## Comments on NorthConnex Project EIS

### Topic – EIS compilation and size

Diagram 1 of 2

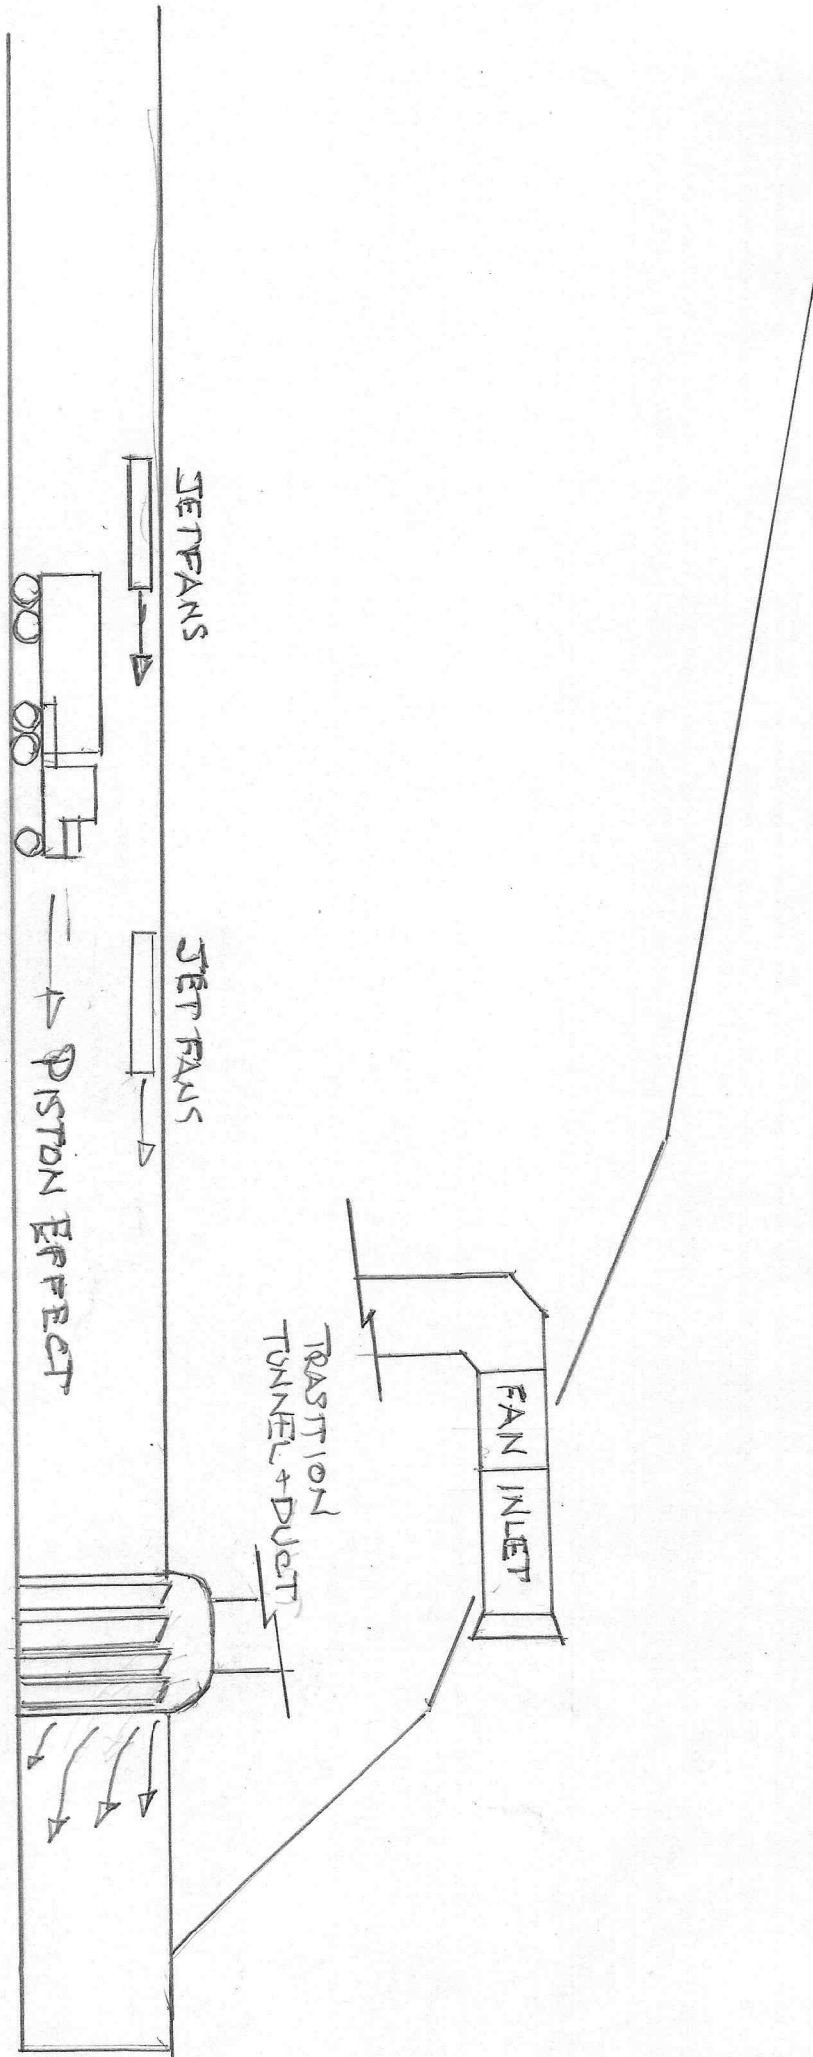
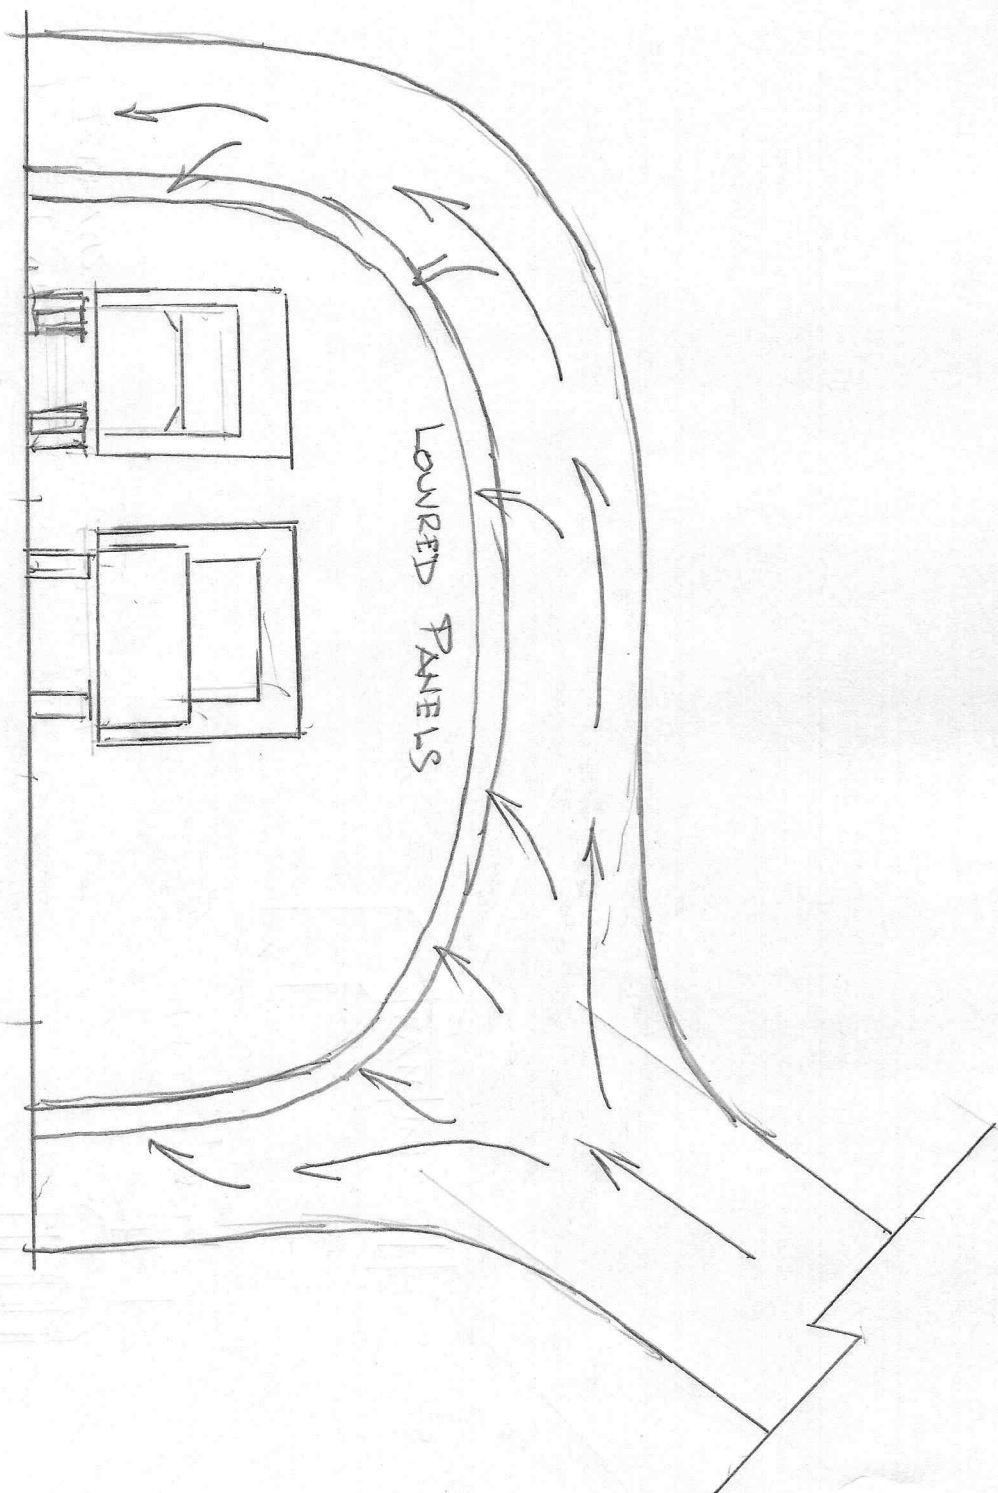
### Topic – Southern Interchange Arrangement and provision for future extension

Comment – The Southern interchange is a major impediment to traffic flows from the M2 westbound and from Pennant Hill Rd leading to unnecessary high gradient exit and exit to traffic

lights at Pennant Hills Rd with the consequent fumes and particulates from start-stop traffic. There should be slip lanes onto and off the M2 on the eastern side as well as the western side to avoid this.

The tunnel should extend past the M2 on the southern side with provision for extension to Silverwater Rd at Dundas Valley – An additional 4.1km that provides a link to the major arterial link road to the M4 and southern Suburbs. The slip lanes from pennant Hills Rd should be on the Southern side of the M2 to avoid the major traffic lights and eliminate the noise and fumes of the stop-start intersection.

Refer to the plan at the end of this document.
